From
The Principal Secretary/
Member Secretary,
Chennai Metropolitan
Development Authority,
No.1, Gandhi Irwin road,
Egmore, Chennai – 600 008

Letter No.PP/NHRB/C/311/2019

Sub: CMDA – Area Plans Unit – ‘B’ Channel (Central) – Planning Permission for the proposed construction of Stilt + 3 Floors Residential building with 6 dwelling units at Plot No.159, 94th Street, 15th Sector, K.K.Nagar, Chennai comprised in Old S.No.85/1 part, T.S.No.196, Block No.26 of Kodambakkam Village within Greater Chennai Corporation Limit. – Particulars Called for –Regarding.

SITE / STILT FLOOR PLAN

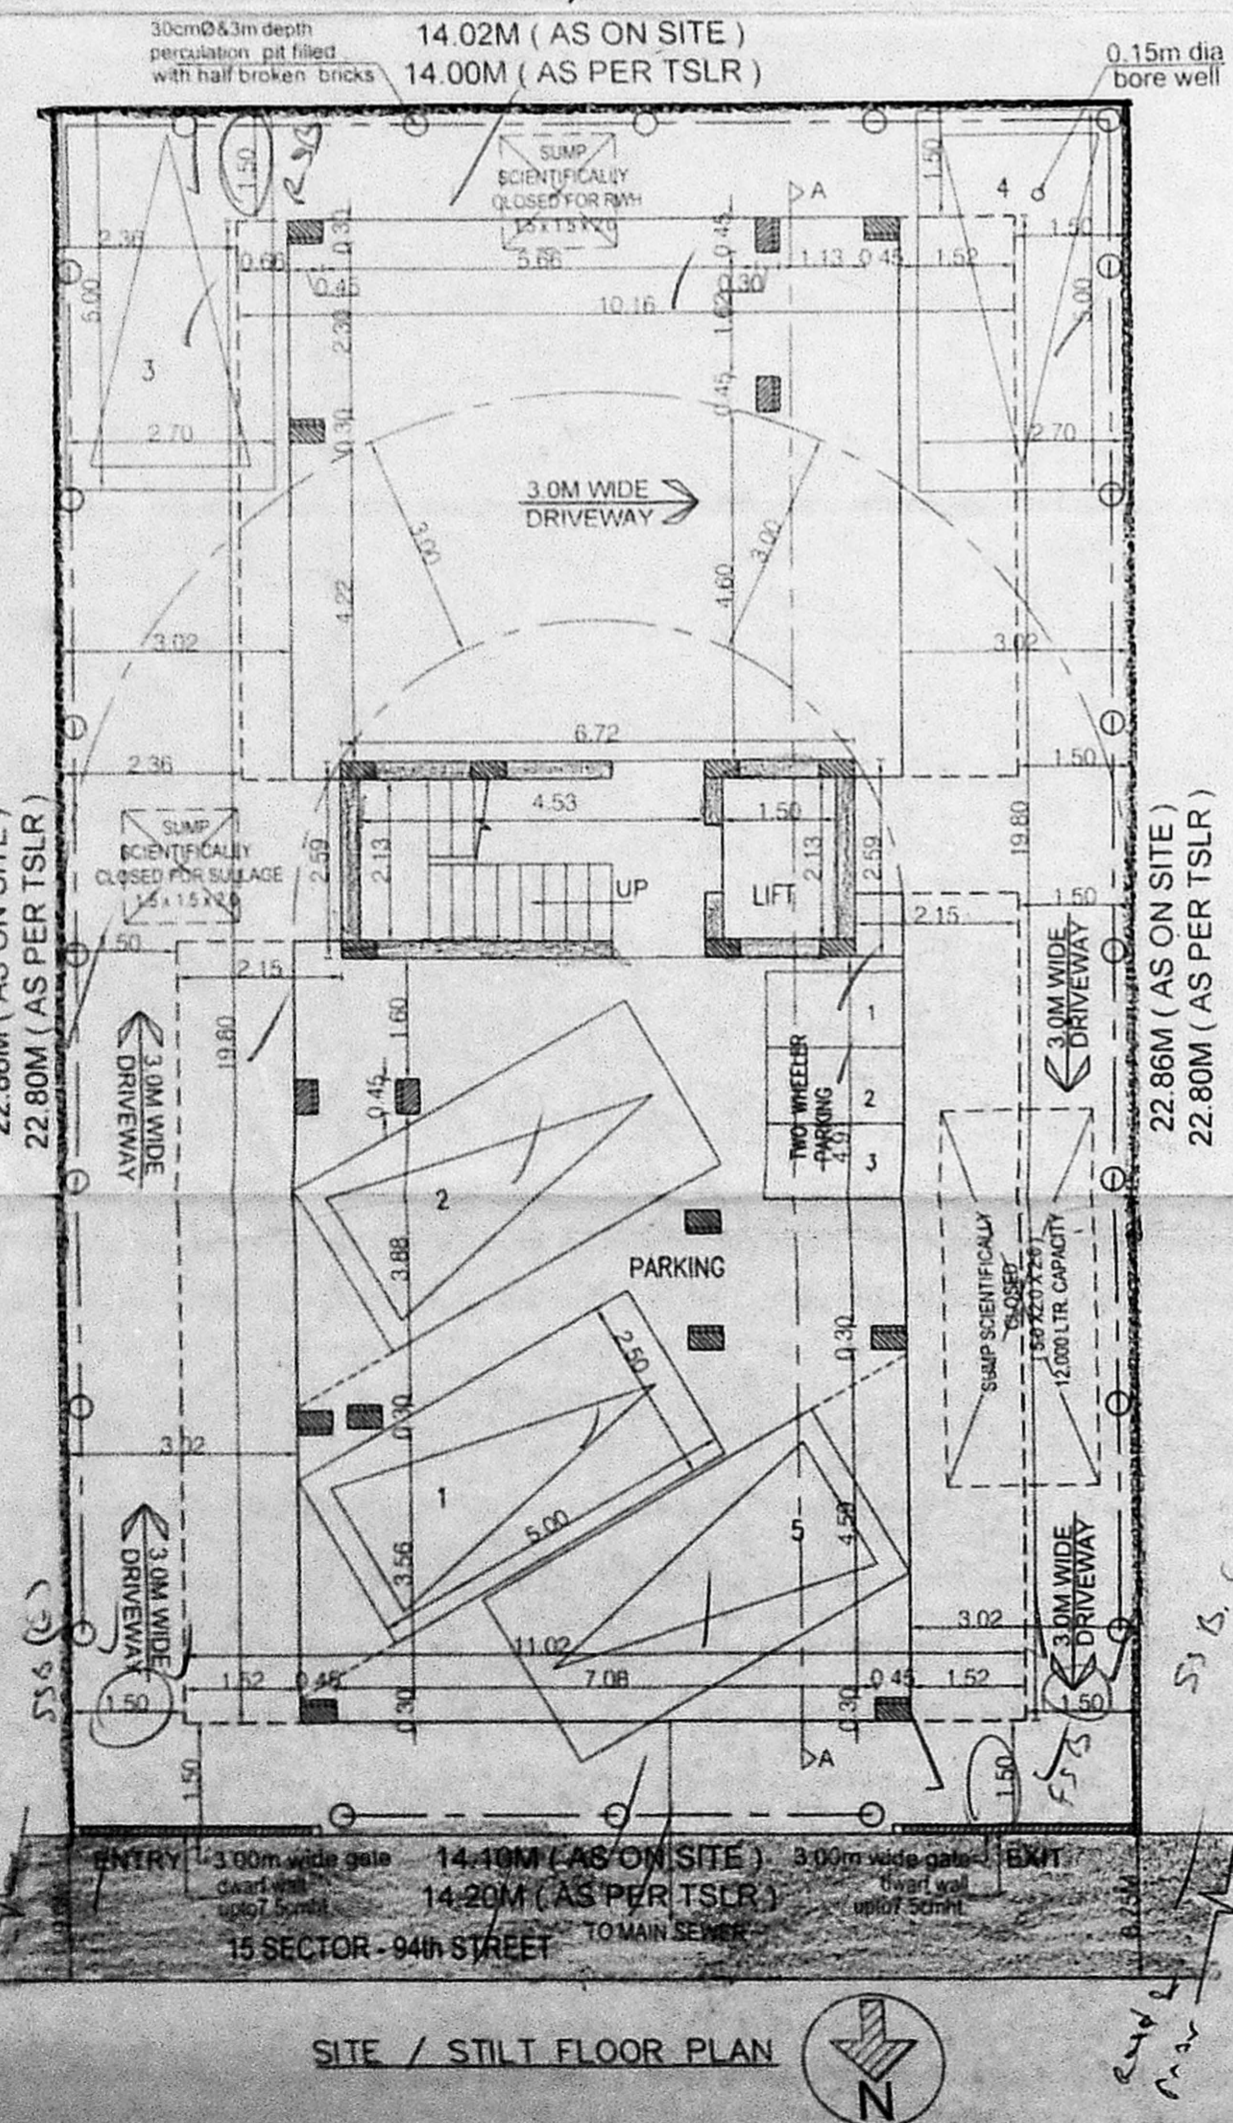
1. D.C. and other charges to be remitted as per the earlier DC advise letter (with effect from 5.7.2019) in the reference 2nd cited and conditions acceptance letter has not furnished.
2. Set back dimensions and building measurements are to be shown correctly.
3. Area statement. Title of plan, Road width, Terrace floor plan, section and Elevation to be shown correctly.
4. CMDA Registration copy for Developer is to be furnished.
5. Form B & Form C in Rs.20/- stamp paper as per the format prescribed in TNCD & BR to be furnished.
